RiverOak Strategic Partners

Applicant's Answers to Fifth Written Questions

TR020002/11/FWQ
Examination Document

Project Name:	Manston Airport Development Consent Order
Application Ref:	TR020002
Submission Deadline:	11
Date:	5 July 2019

ANNEX 3
PRoW PLAN

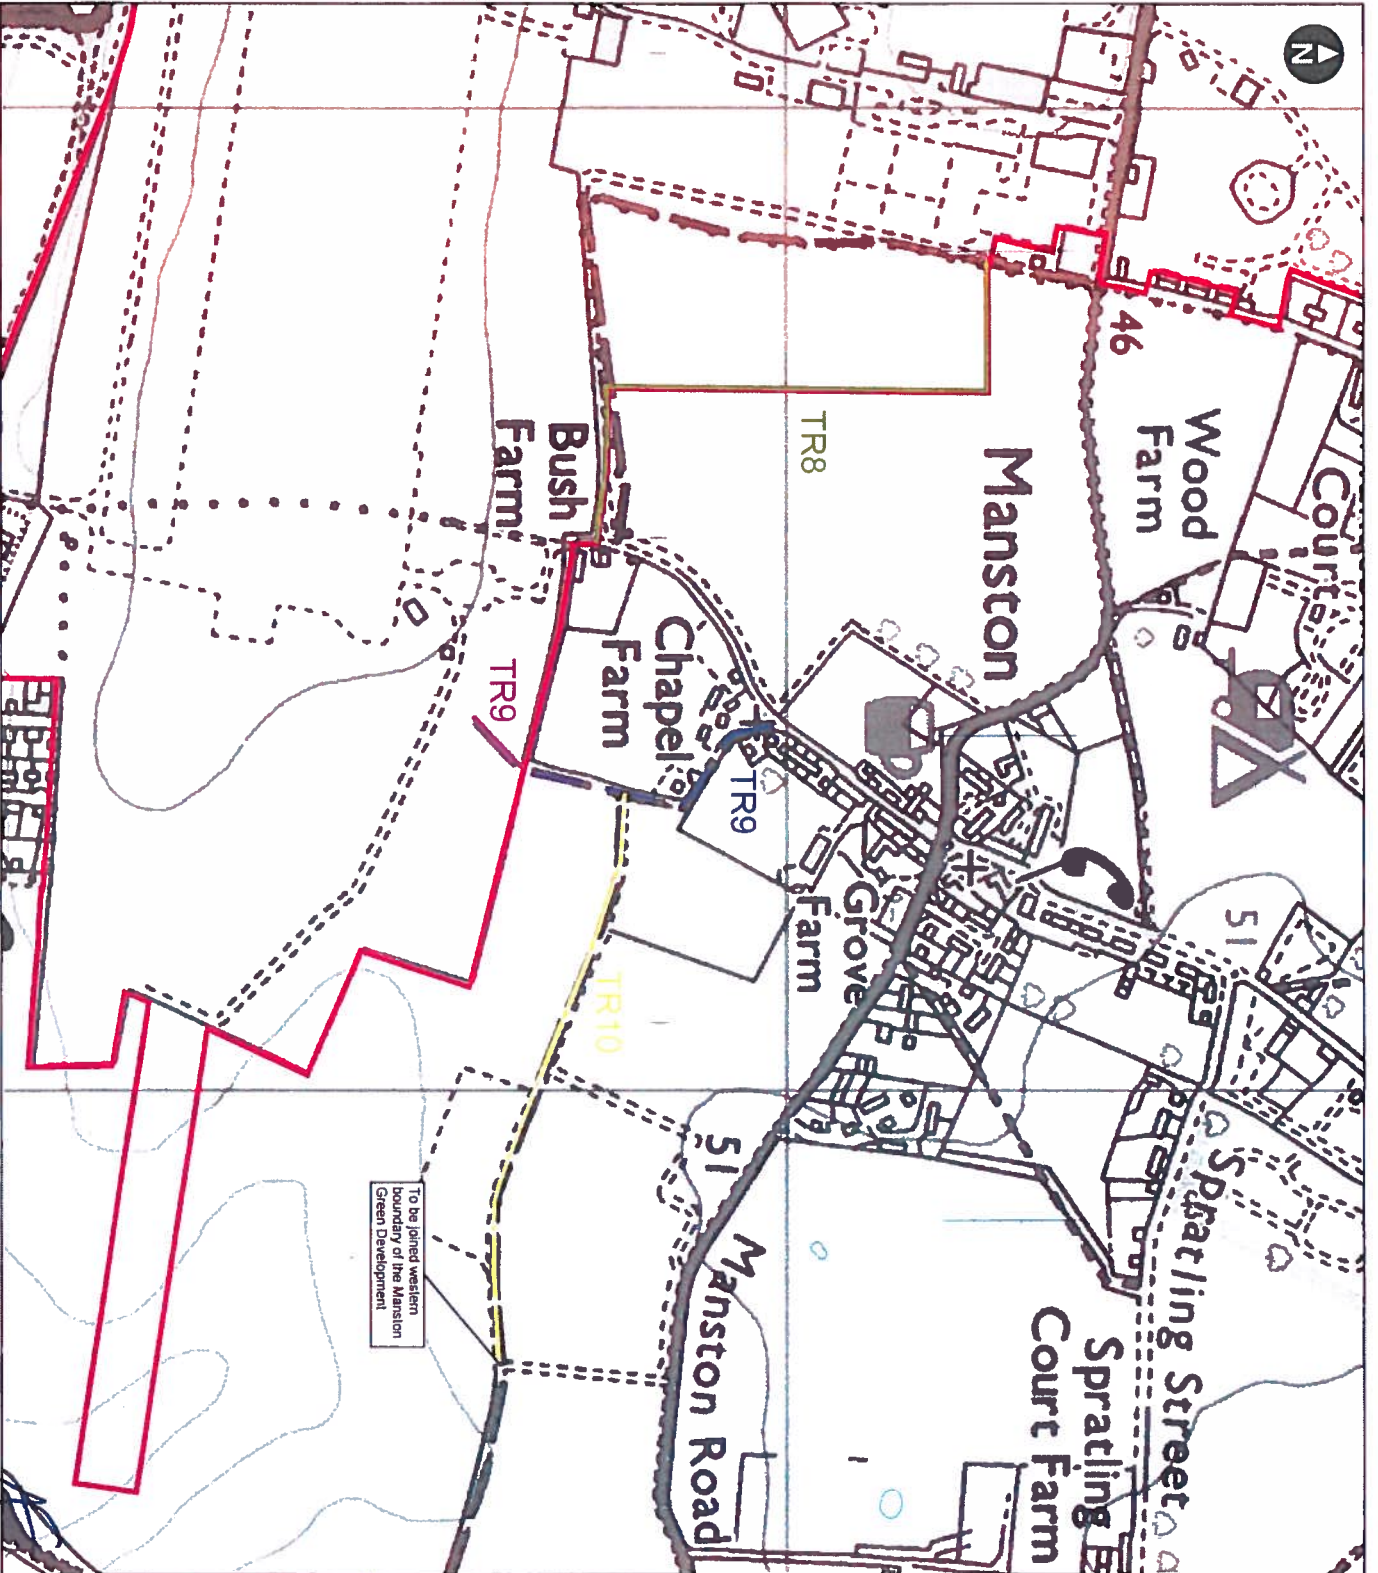
Ref No.	Respondent	Question
		<p>There are two signs that already indicate "Manston" with an airport symbol which don't need replacement.</p> <p>Of the 17 other signs, whilst not all require complete replacement, a cost for this has been included. The S106 agreement includes a contribution of £7,650 based on a unit cost of £450 and 17 signs.</p> <p>The Applicant has already limited used on the Northern Grass Area as aviation related development, and defined aviation development in the Statement of Need.</p>
TR.5.14	The Applicant	<p>Manston Village Pedestrian Links</p> <p>KCC's responses to fourth written question TR.4.54 [REP9 – index number to be allocated] states:</p> <p><i>"An obligation to fund an upgrade of TR10 is welcomed; however, in isolation, this does not provide appropriate connectivity between the terminal building, Manston Village and future residential settlements to the east.</i></p> <p><i>Journeys to and from the site would also rely on travel within parts of PRoW TR8 and TR9... As such these routes also require improvements to enable them to be used all year round".</i></p> <p>Further, KCC has suggested alternative costings.</p> <p>What is the Applicant's response to these matters?</p>

<p>Applicant's Response:</p> <p>The Applicant is committed to improving Public Right of Way (PRoW) TR10 and TR8. Details of the costing methodology for TR10 were provided to the ExA at Deadline 10, within Appendix TR4.54. The Applicant invites Kent County Council (KCC) to review this document which was submitted on Friday 28 June.</p>

Ref No.	Respondent	Question
		<p>The Applicant engaged with the KCC PRoW Officer in developing costings and as a result a detailed methodology for understanding the costs of upgrading PRoW was provided by KCC. This was used by the Applicant in all calculations, hence the methodologies employed by KCC and the Applicant are the same.</p> <p>The difference in cost for upgrading PRoW arises due to KCC considering the total length of existing PRoWs. As Appendix TR4.54 states, the section of TR10 which passes through the Manston Green development will be diverted and delivered by that committed development, and not by the Applicant. The Applicant has therefore provided a cost for upgrading 666m of TR10, while KCCs costs consider a total length of 964m. TR8 requires upgrading and diverting as a result of the development proposals, resulting in a shorter route. The total length of the diverted TR8 would be 789.4m, compared to its existing length of 889m. The Applicant has provided costs based upon the diverted route which are appropriate.</p> <p>TR9 does not require upgrading since the section of the route between TR10 and High Street is already paved. The remaining section of TR9, south of TR10, enters a field prior to reaching the airport boundary and becoming a dead end. As that section does not provide the connectivity between Manston Village or Manston Green Development and the Manston-Haine Road, there is no merit in upgrading this path.</p>

Manston - Haine Link
Land for Safeguarding
Sheet 1

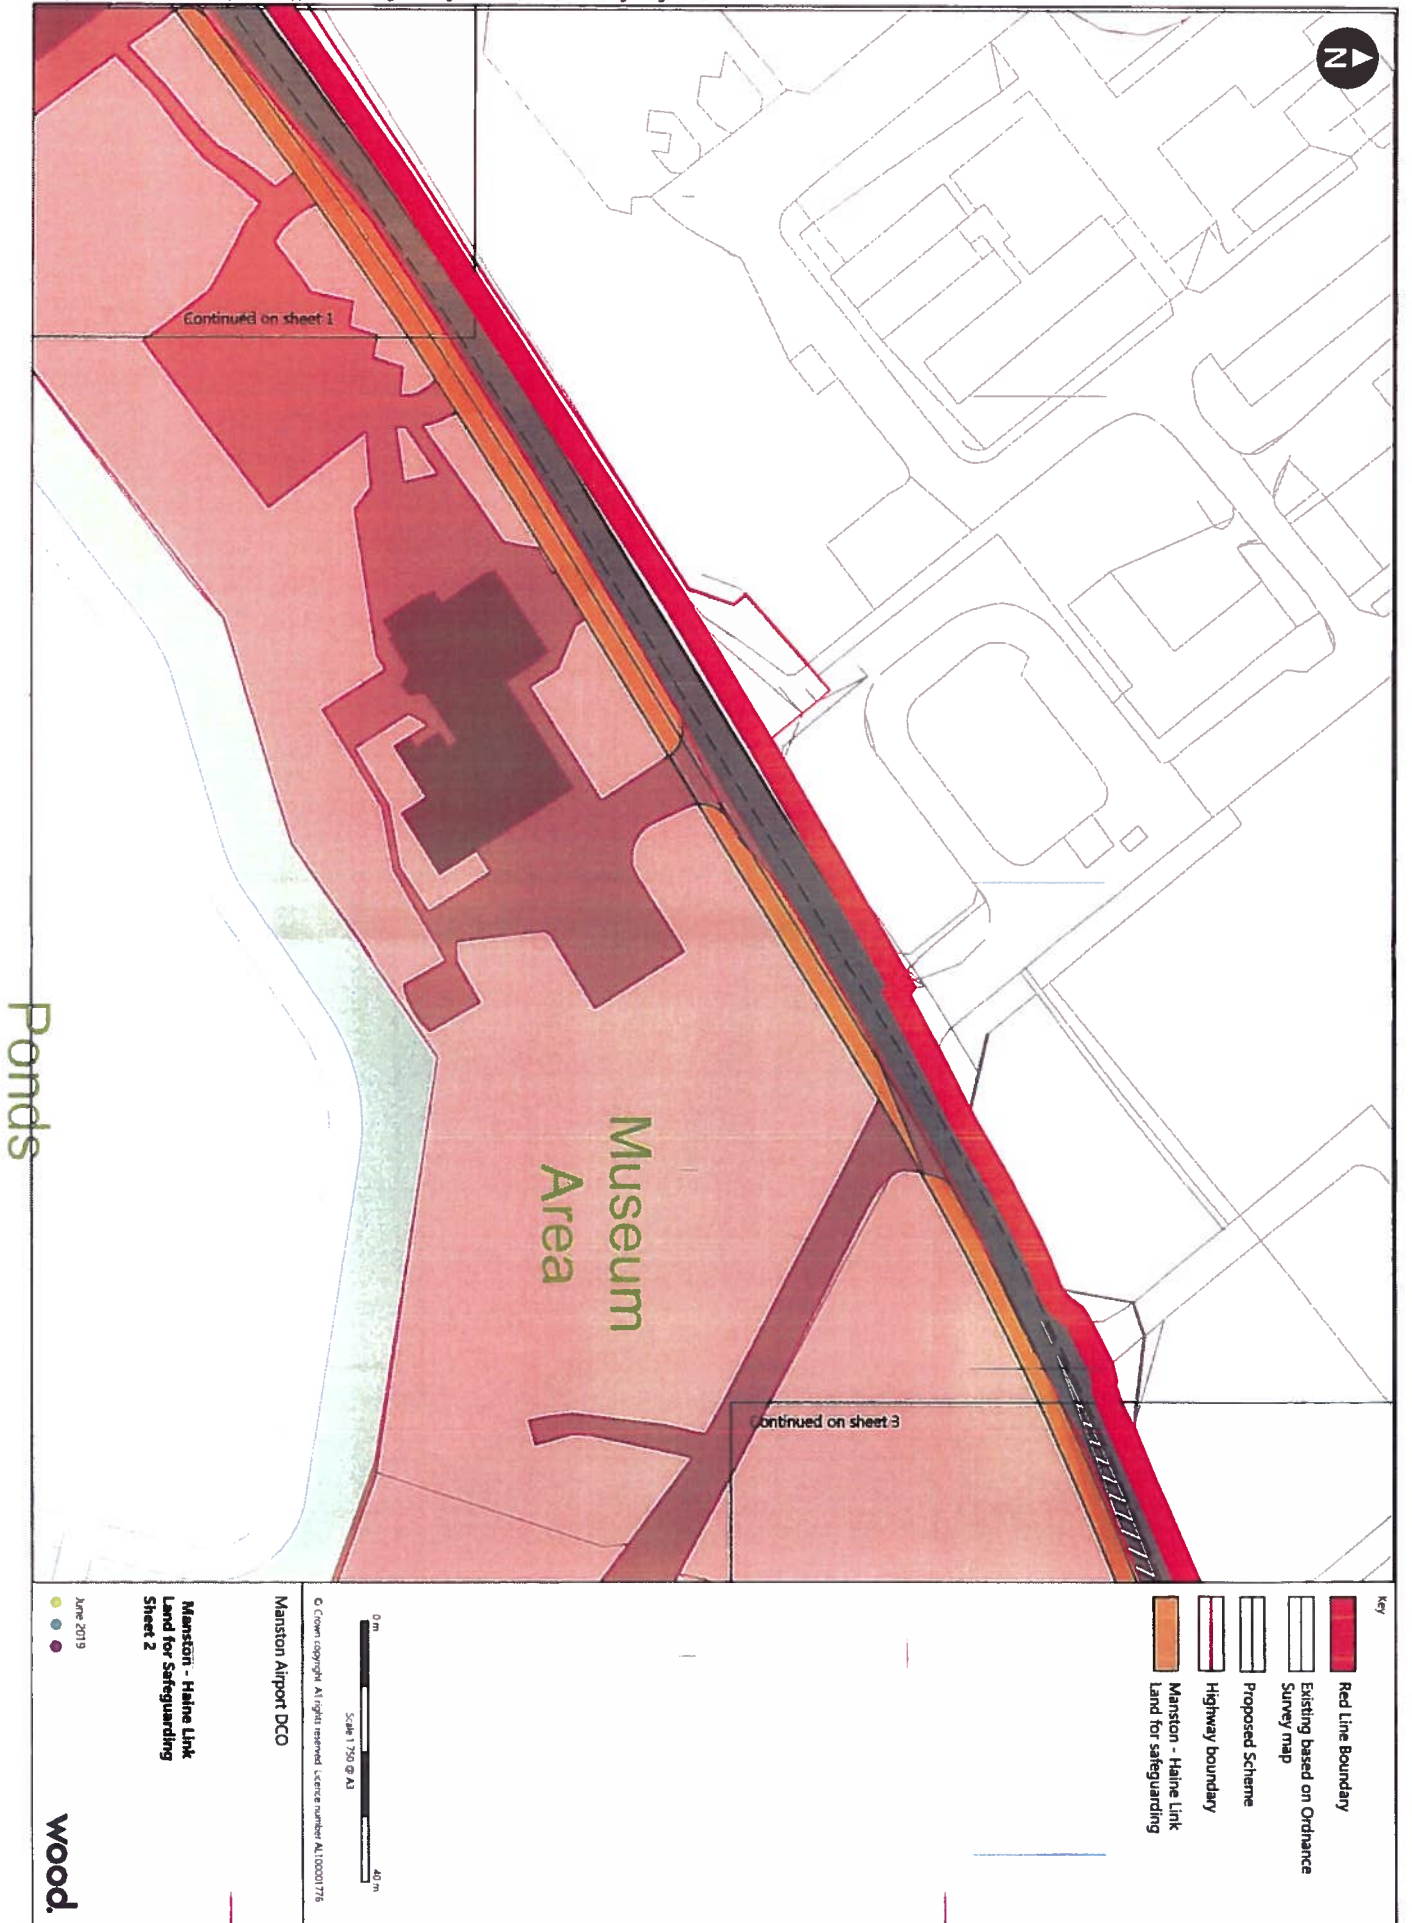
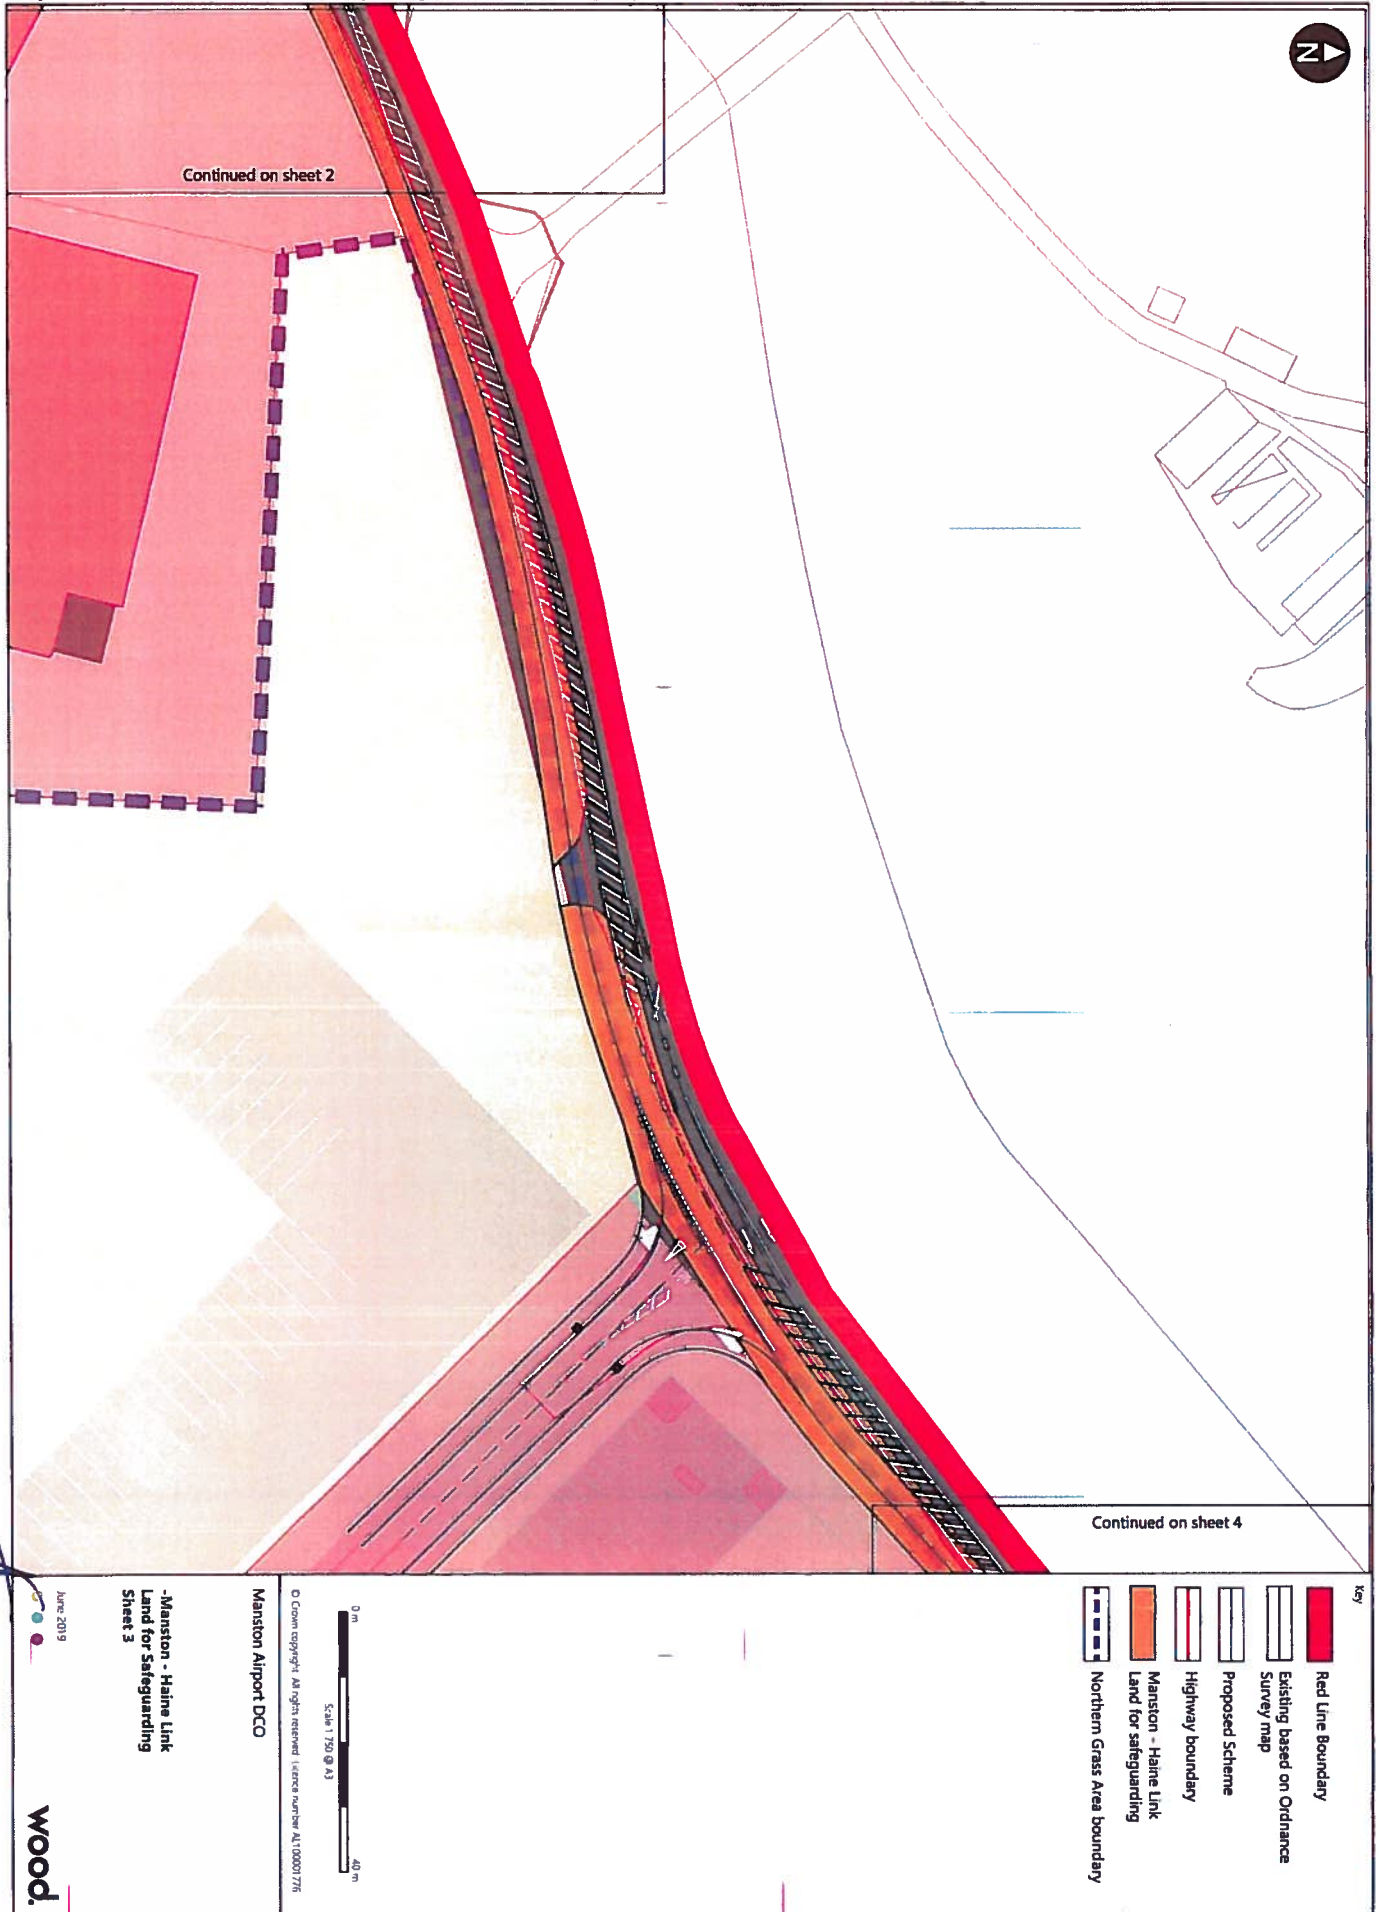
Ref No.	Respondent	Question
TR.5.2	The Applicant	<p>Manston-Haine Link Road</p> <p>KCC's response to fourth written question TR.4.12 [REP9 – index number to be allocated] states:</p> <p><i>"KCC has reviewed the proposed land safeguarding plans and would request that the offset to the South/East of the proposed road is increased to 10 metres for areas contained within Sheets 5&6 and a 5-metre offset for remaining areas of link southbound towards Manston Road/Spitfire Way junction.</i></p> <p><i>KCC requires safeguarding of land required to deliver an appropriate form of junction at Spitfire Way. This has not been included within the submitted plans and as such remains unresolved. In the absence of an agreed position in relation to the Spitfire Junction design, it is important for as much land to be encompassed within the safeguarding area as possible, to provide scope to alter the junction accordingly. This is essential to ensure that the mitigation offered by the Applicant is deliverable in practice.</i></p> <p><i>All plans should be annotated in the corresponding colour to denote exactly the extent of land being safeguarded as the areas shown in Pink are not currently annotated within the corresponding key".</i></p> <p>What is the Applicant's response?</p>

<p>Applicant's Response:</p> <p>The Applicant remains of the view that extending the safeguarding area to 10m is excessive. The 4m safeguarded area to the east side of the proposed road is more than sufficient for the purposes of construction and also allows some flexibility in the route alignment. As the ExA is aware, the Applicant has offered to gift the land to KCC and has provided more land than is necessary both on the western side of the suggested alignment and also the entire north west corner of the site has also been safeguarded.</p> <p>In circumstances where KCC needed to obtain the land outside of the DCO Examination it would have to promote its own Compulsory Purchase Order. In these circumstances, KCC would need to define the precise area of land required, the need for it, the deliverability of the proposed development and numerous other factors including an understanding of the</p>
